Planning Application Ref: AW/55/18/HH

Location: 3 The Orchard, Aldwick

Description of works: Rear and side, single and two storey extension incorporating rear balcony.

EXISTING PLOT PLAN

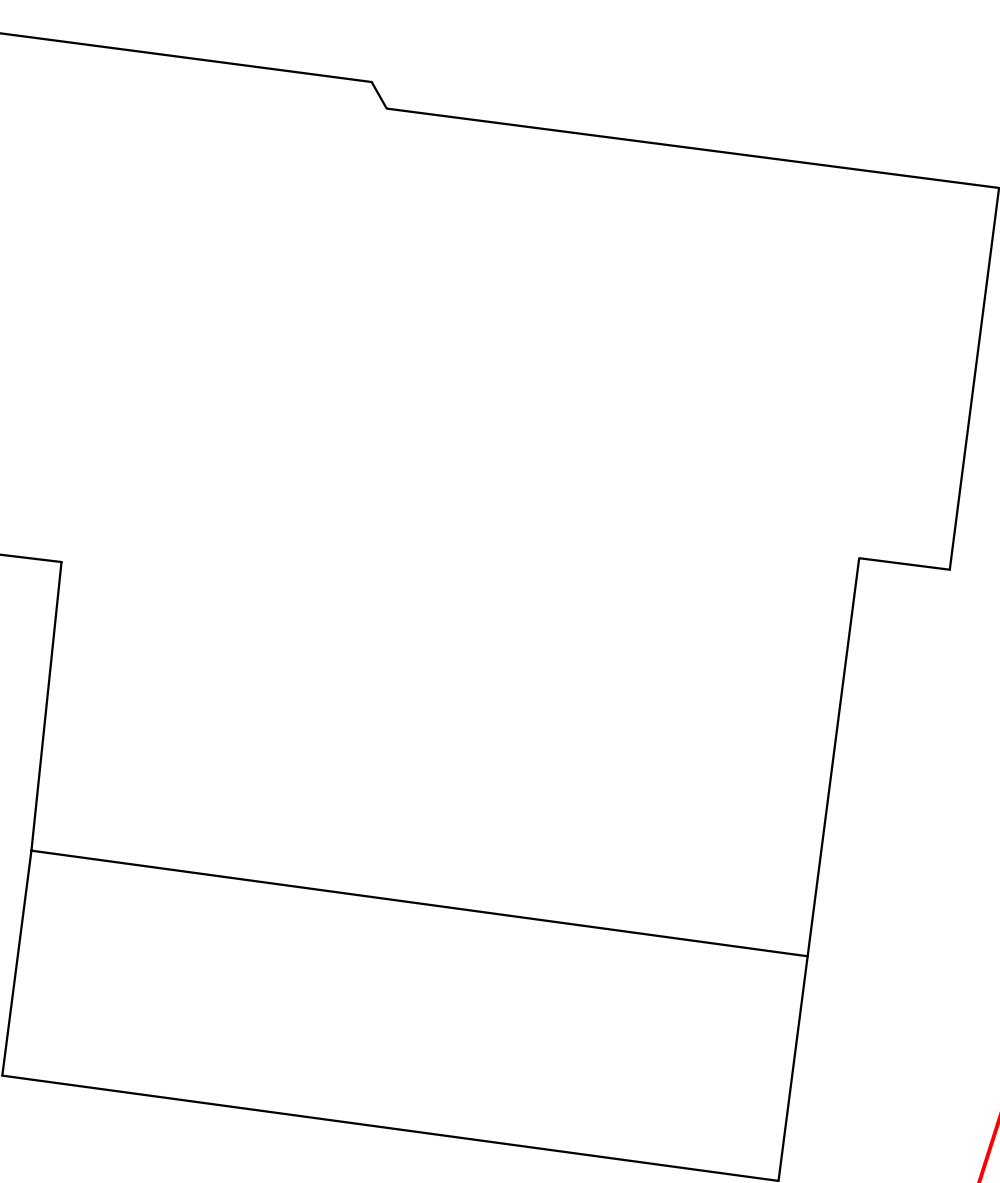
- The applicants have had their Building Contractors prepare a supporting arboricultural assessment with photographic evidence included.
- This does not conform to BS5837 requirements and is not sufficient in this instance for me to make a valued assessment of this application as it stands. However, it would seem somewhat over the top to require a full assessment on such a small project.
- I note that the intention is to remove the Birch and also the Laurel and I have no objection to this as neither makes a significant impact in the landscape.
- The proposal is to retain the Leylandii hedge and the Cherry tree at the rear and my concerns here are that there is no Tree Protection Plan to show how these trees will be protected during the construction process.

- The Leylandii and Cherry will require to be protected in accordance with BS5837 recommendations and for this they will need to employ the services of an Arboricultural Consultant to prepare and submit a Tree Protection Plan on their behalf.
- As it stands whilst I do not object to the principle of development as proposed there has been insufficient arboricultural information supplied and this I do raise an **OBJECTION** to.
